Advice to the local planning authority

To LPA	Kirklees
LPA planning ref no	2023/62/93113/W
Our ref	pgo-5066
Site address	30, Market Street, Huddersfield, HD1 2HG
Proposal description	Change of use and alterations to form student living accommodation with ancillary concierge and communal facilities including roof extension and roof terrace
Date on fire statement	Undated
Date consultation received	04/04/2024
Date response sent	01/05/2024

<b>CLIENT DETAILS</b> MARKET STREET HUDDERSFIELD	<b>DRAWING No</b> NTL-PL-010	<b>REVISION</b>
<b>DRAWING INFO</b> Elevations as Proposed	<b>SCALE</b> 1:100	<b>DATE</b> 29/09/2023
		<b>DRAWN BY</b> JH

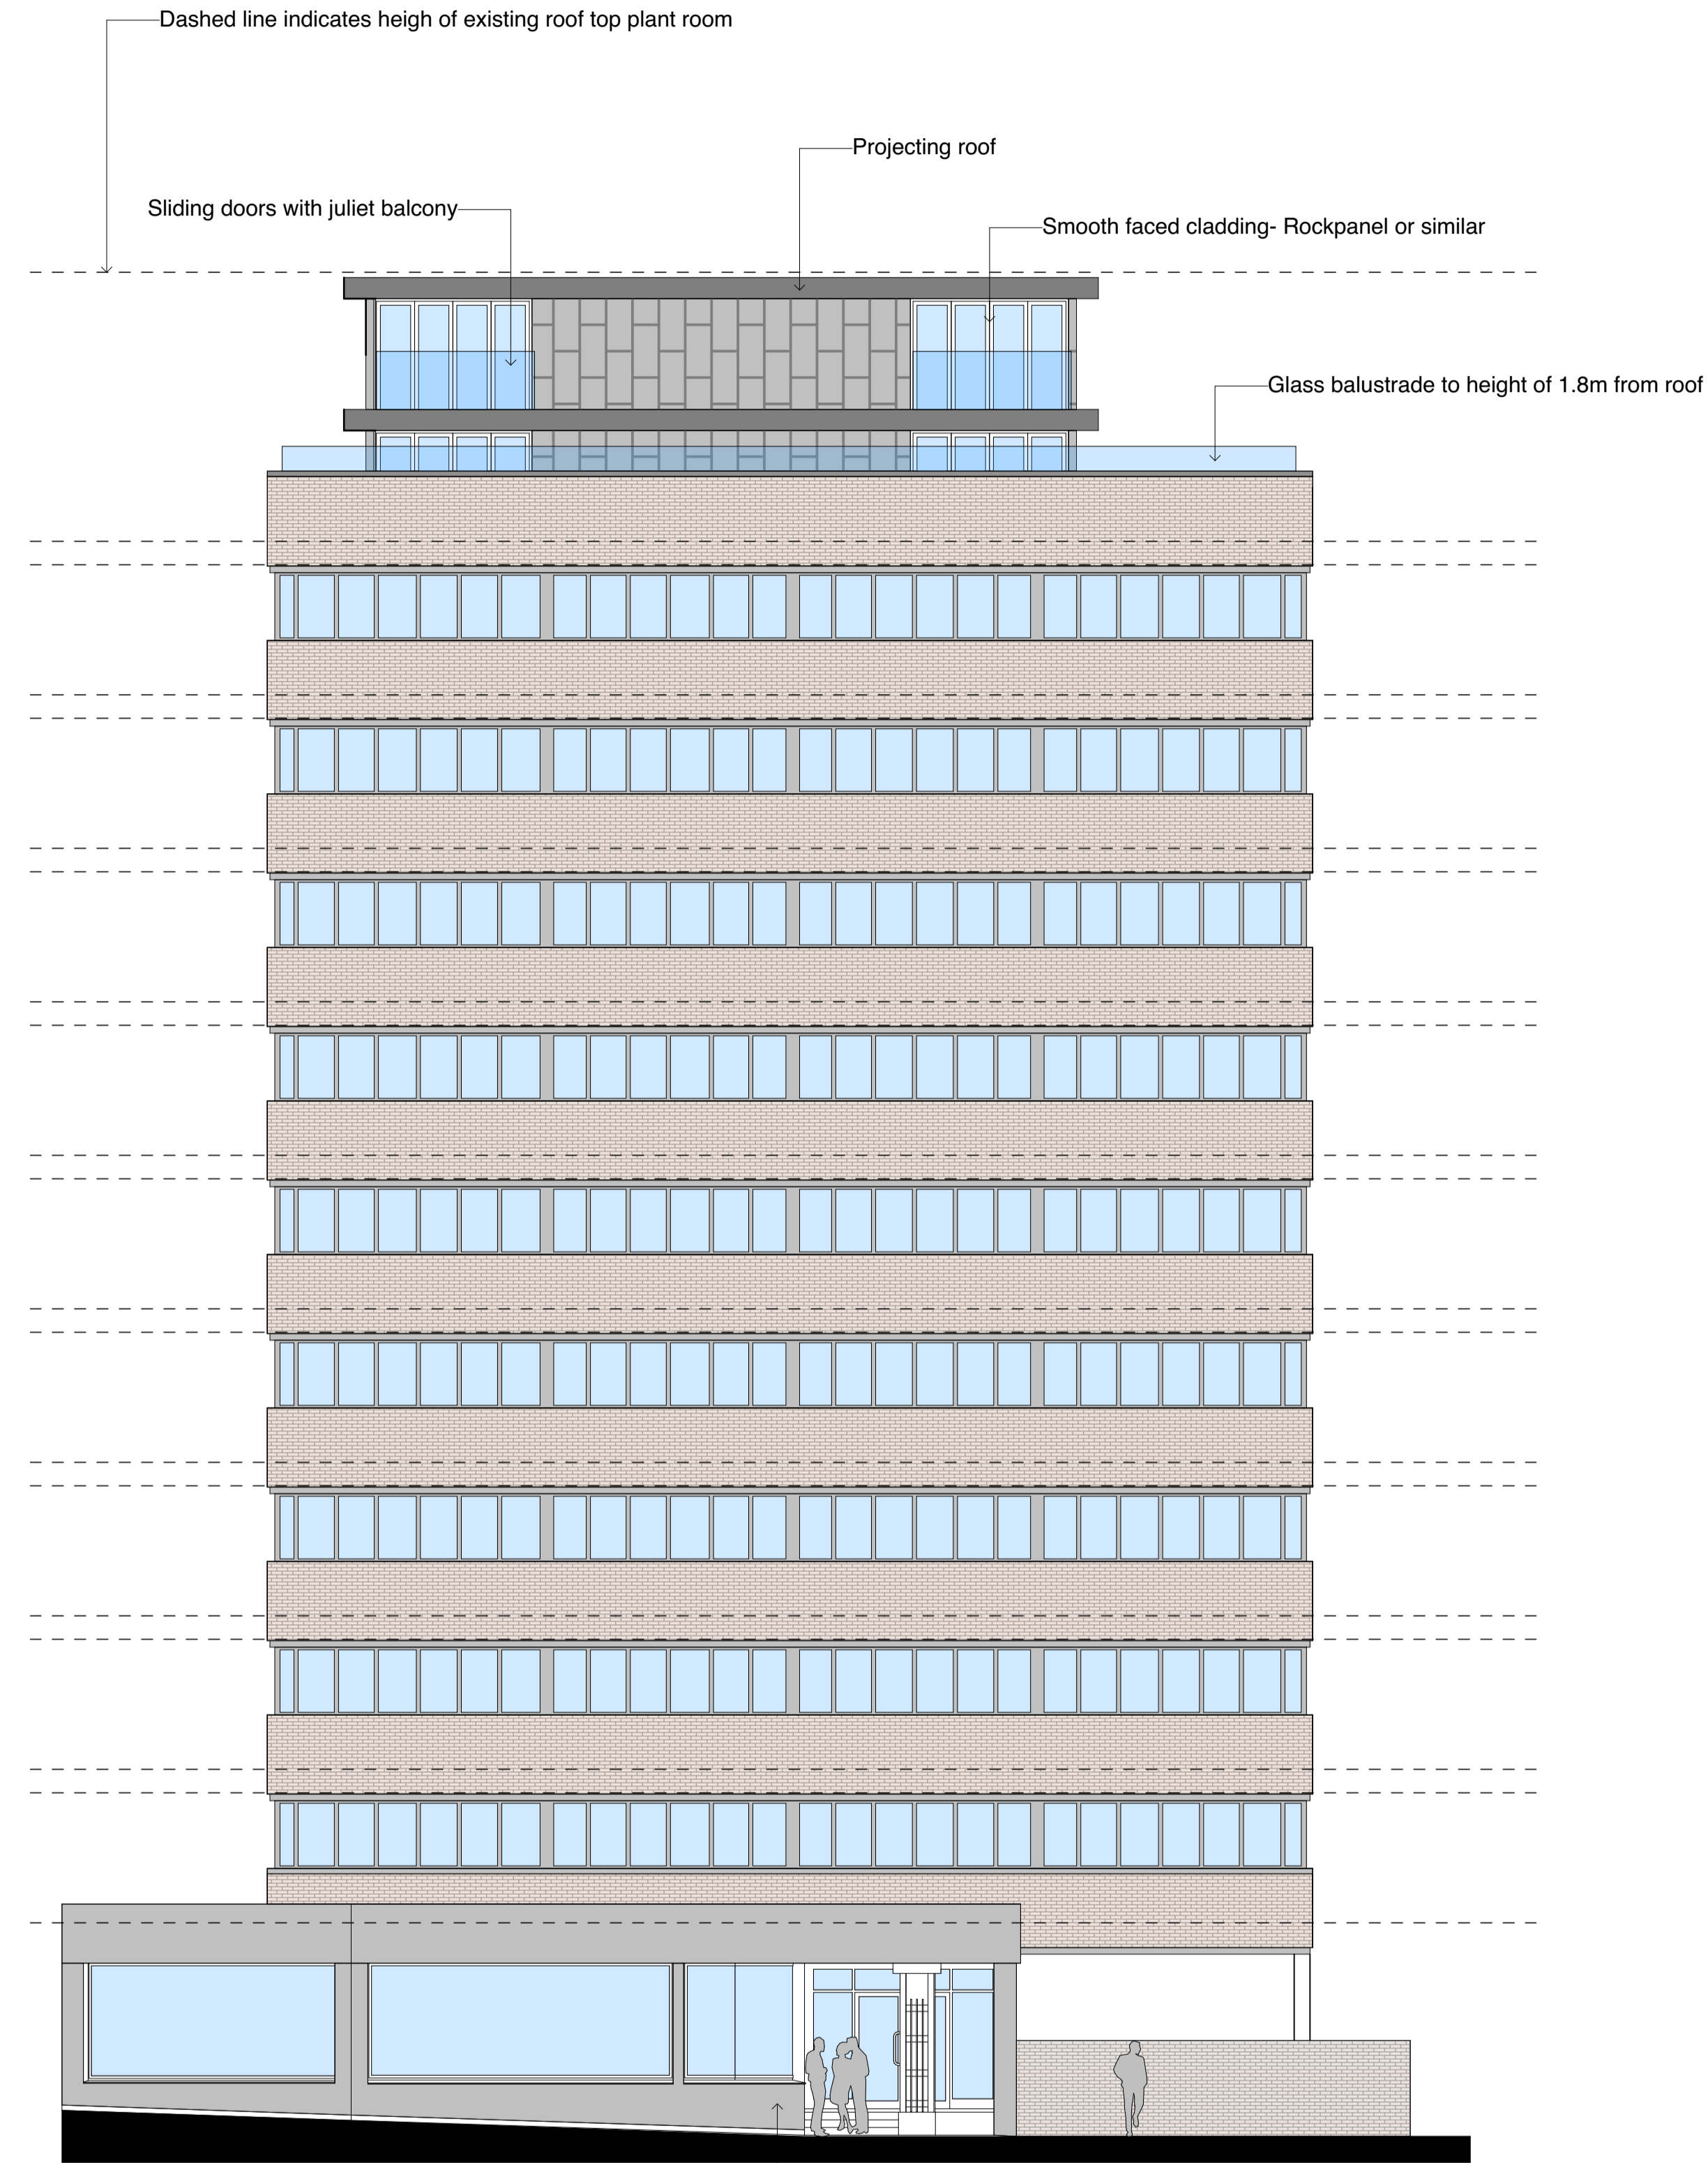
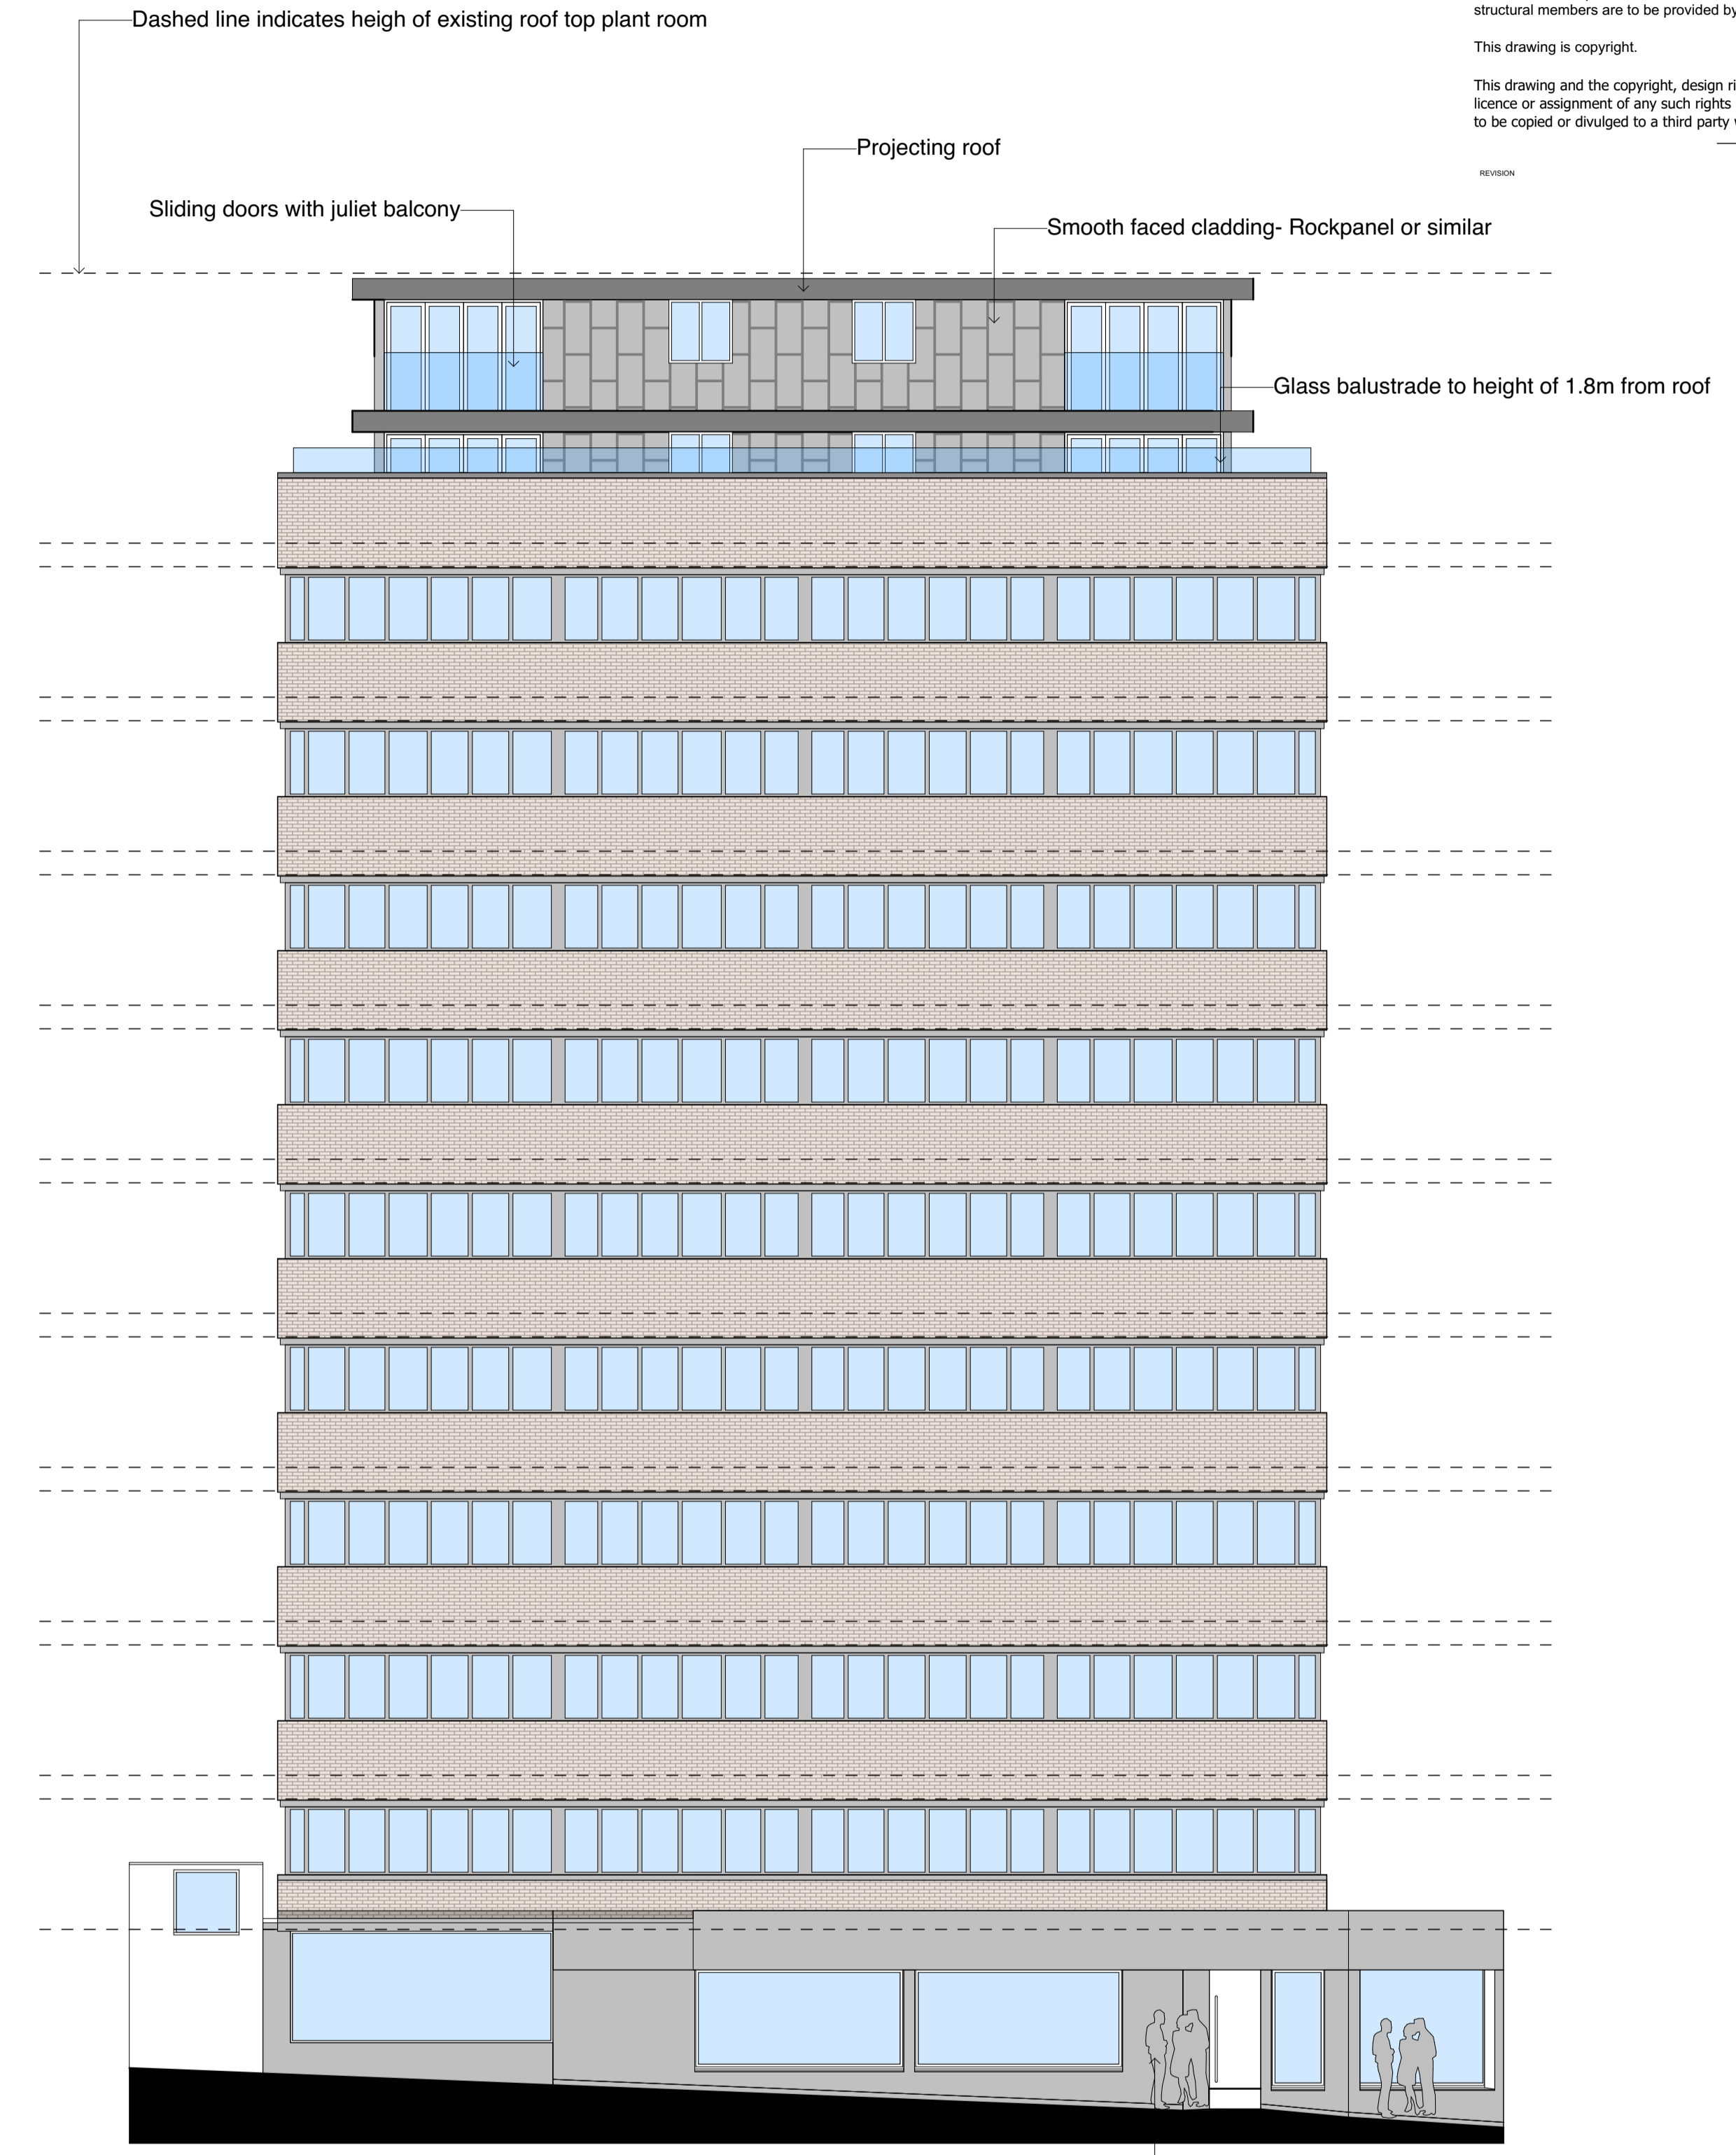
- 2.3. Page 7 of the Design and Access Statement states: *“The two extra floors shall be constructed in lightweight construction and clad with an anthracite grey cladding.”* Additionally, page 3 of the fire statement states: *“The buildings external wall construction as existing is a non-combustible material and the **proposed external cladding to the extra floors shall also be non-combustible cladding with at least a classification of A2-s1,d0** to EN 13501-1 in accordance with the building regulation’s 2010 (as amended).”* This is noted and it will be for the applicant to demonstrate compliance at later regulatory stages.
